From: Martyn White
Sent: 30 August 2019 10:25
To: Planning.Responses <Planning.Responses@arun.gov.uk>
Cc: Amber Willard <Amber.Willard@arun.gov.uk>
Subject: BR/230/19/HH

BR/230/19/HH

C		
B		
A		
Client	H.D. Buschhaus Esq.	
Address	22-24 Upper Bognor Road : Bognor	
Drawing	EXTERNAL ALTERATIONS	No. 4919:1
Scale	1:100	Drawn 2 Date 00/1/19

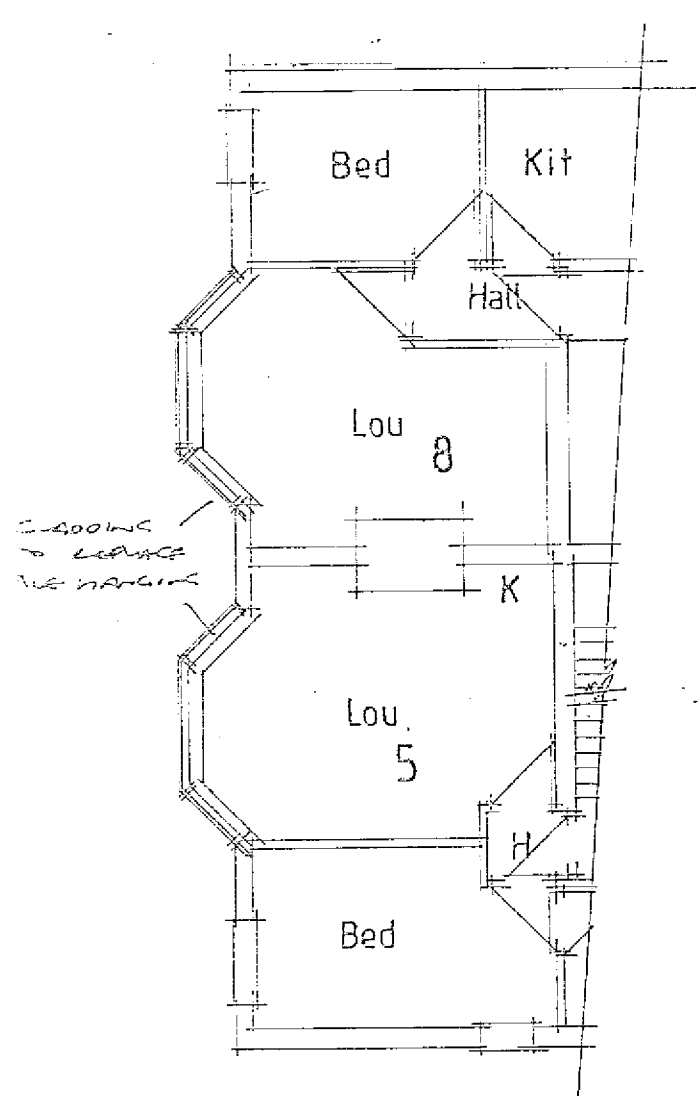
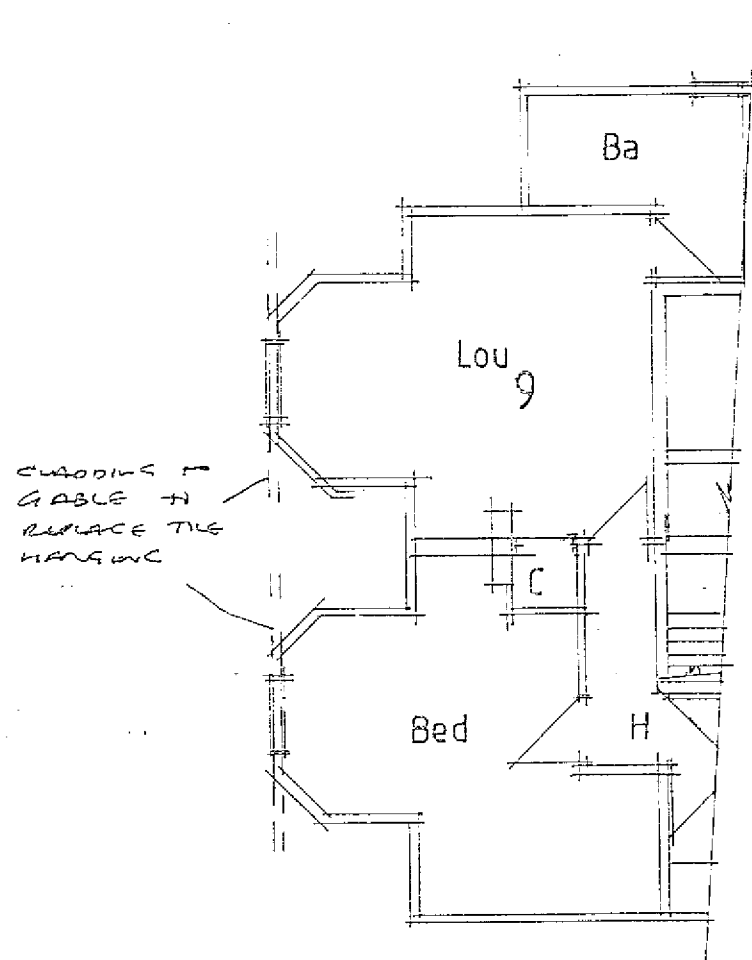
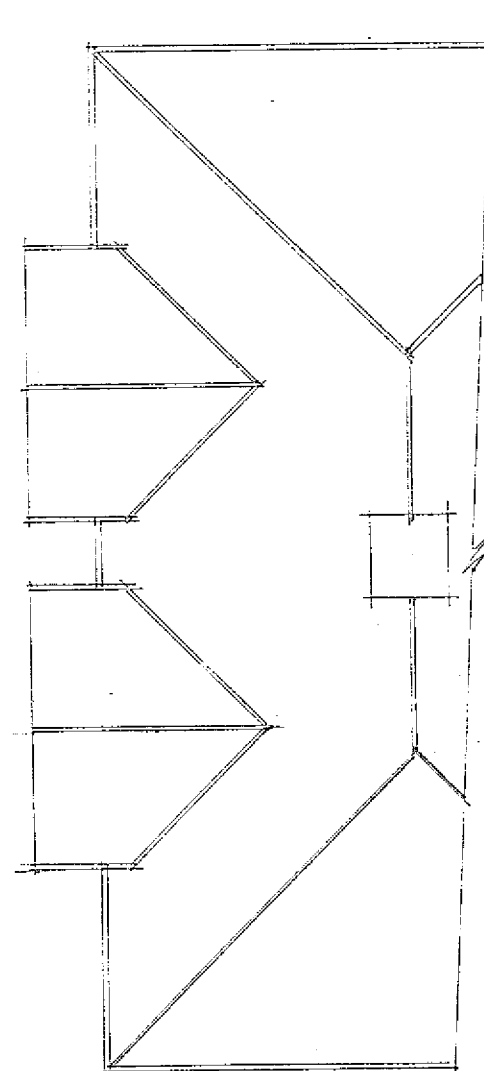
The application is to replace an area of tile hanging with black cladding (PVCU) to both bay windows and gables. The introduction of the proposed material would not only introduce an unsympathetic material, it would further erode the character of the building.

Therefore, the proposal is such that the impact can be described as causing less than substantial harm in accordance with paragraph 196 of the NPPF (2018). The level of harm is considered to be on the lower end of the scale.
